Planning Application Ref: A/166/19/RES

Location: The Laurels, Dappers Lane, Angmering, BN16 4EN

Description of works: Approval of Reserved Matters following Outline consent (Reference A/74/18/OUT) relating to the layout, scale, appearance and landscaping for the erection of 9no two storey dwellings consisting of 2no two-bedroom dwellings, 3no three-bedroom dwellings and 4no four-bedroom dwellings

Mark Warwick
Tree Officer / Parks and Greenspace Team

Client Mr A Carter Project Title and Location The Laurels, Dappers Lane, Angmering	Drawing Title Tree Retention and Protection Plan
Scale 1:250@A1	Drawn LB
Approved GS	Date 03.05.18
Drawing No LLD1392-ARB-DWG-002	Revision 02

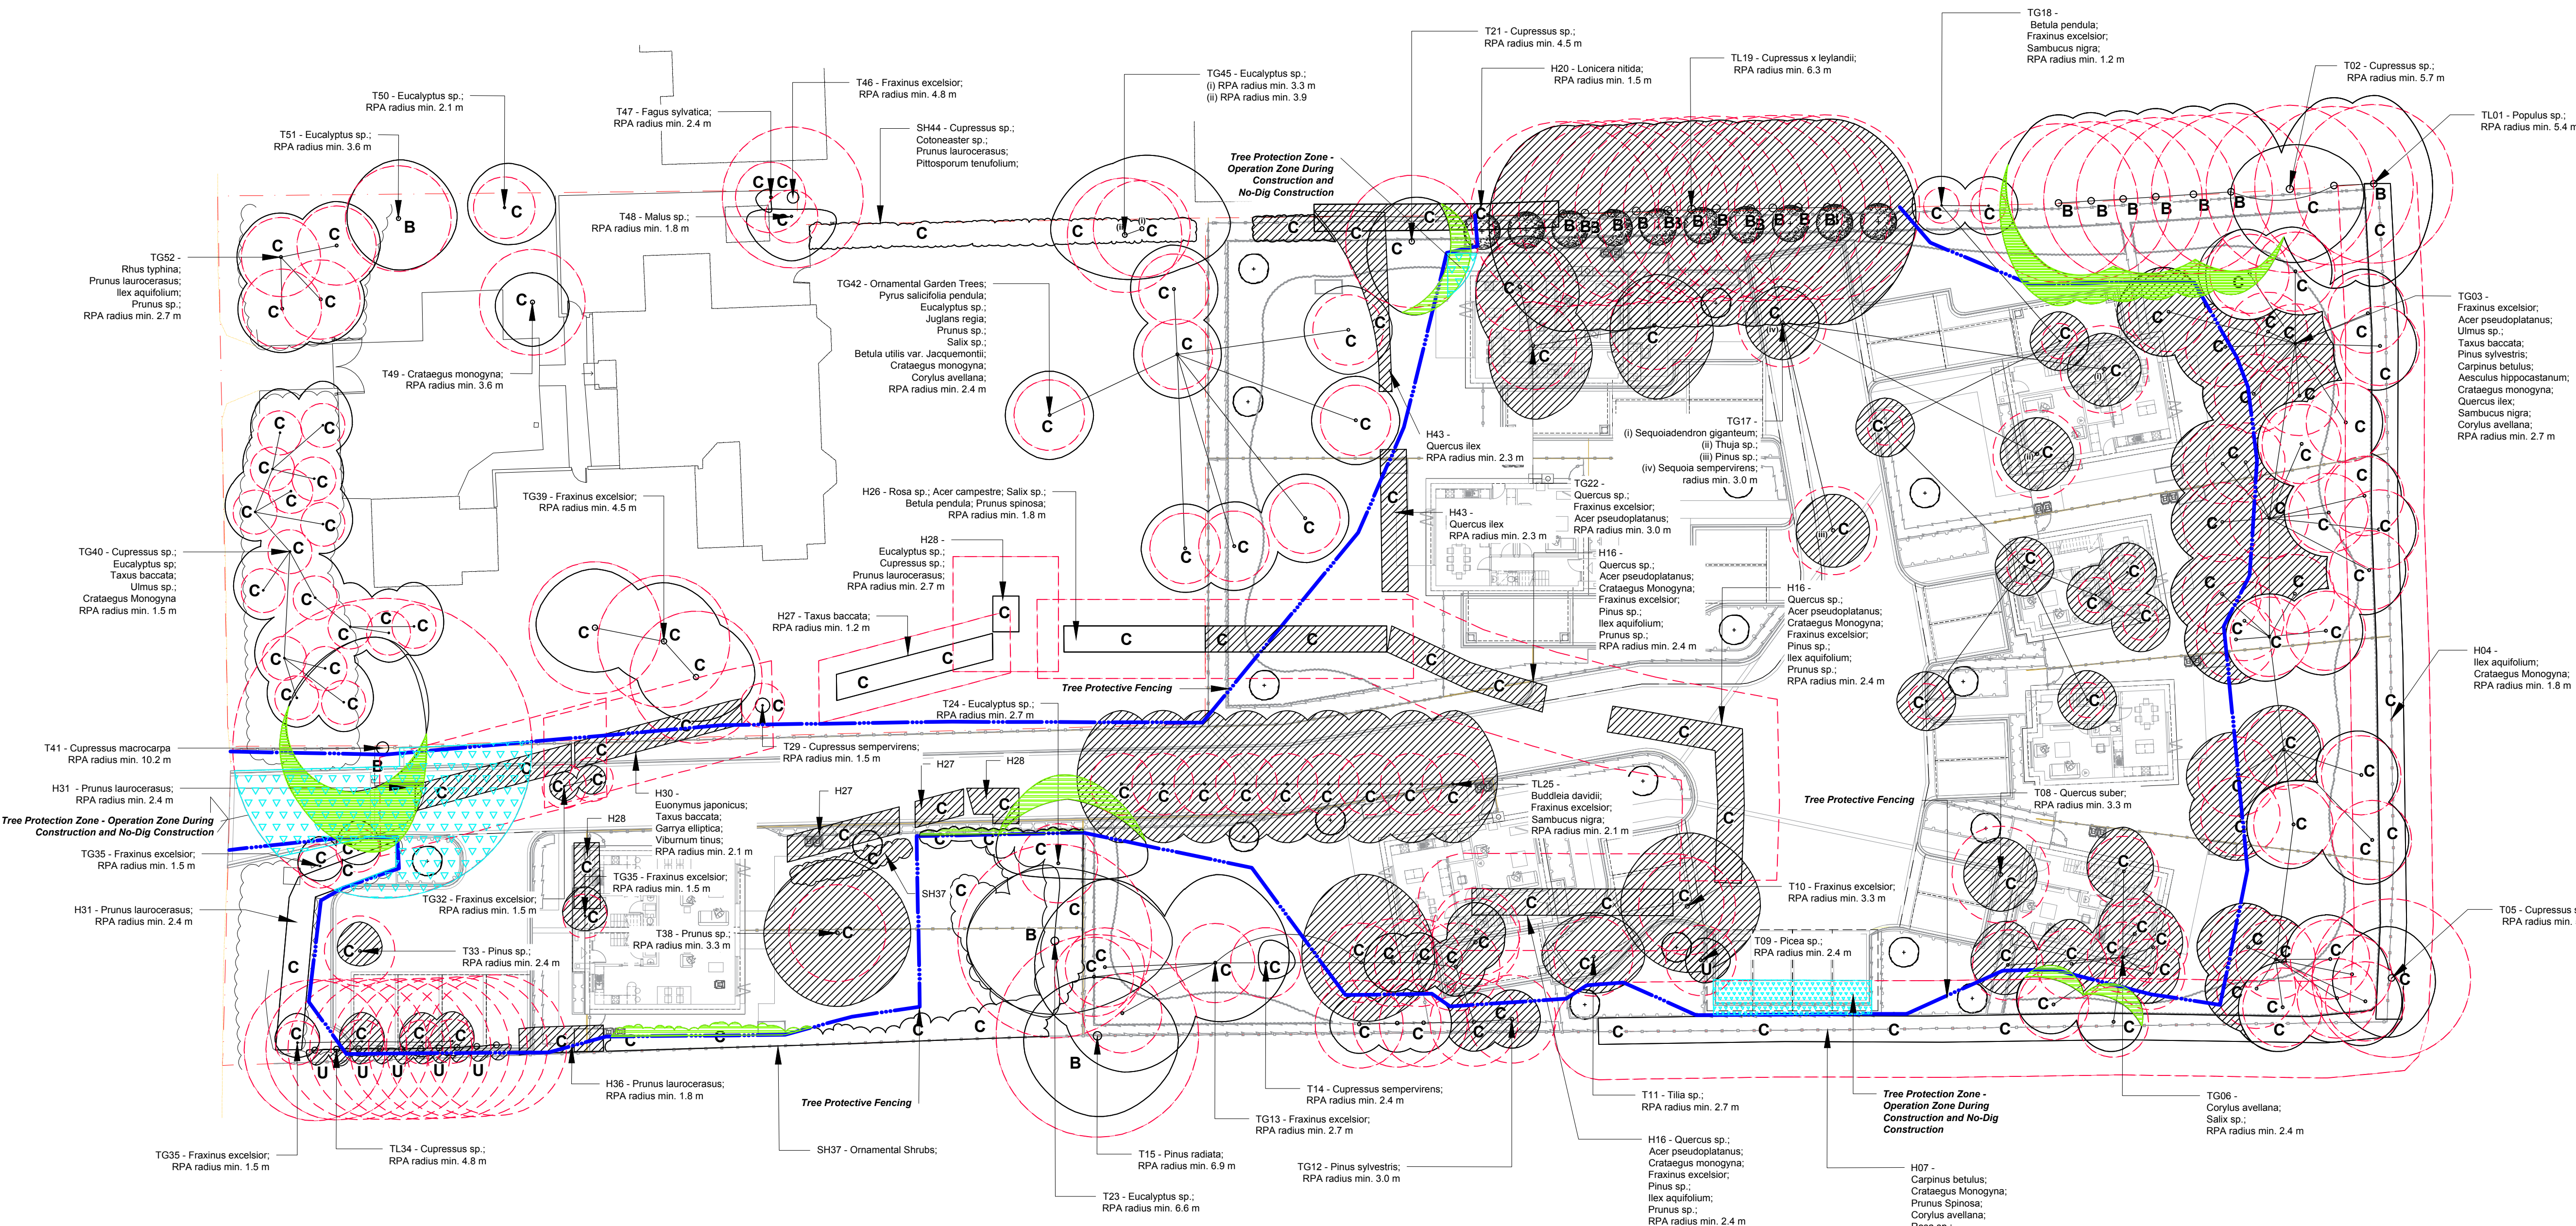
- If you are of a mind to approve the above scheme, I recommend the following conditions be applied:
 1. Before the site is occupied or any machinery is introduced to the site or demolition work or construction work or alterations to existing ground levels takes place a **PRE-COMMENCEMENT Site Meeting** is to take place between the Planning Authority's Tree Officer and the Arboricultural Expert representing the site owner(s) – at this meeting all protective fencing and ground protection measures will be inspected to verify they are 'Fit for Purpose' as required under British Standard 5837:2012 and have been erected and positioned exactly as shown on the **Tree Retention and Protection Plan, LLD1392-ARB-DWG-002, Rev 02.**
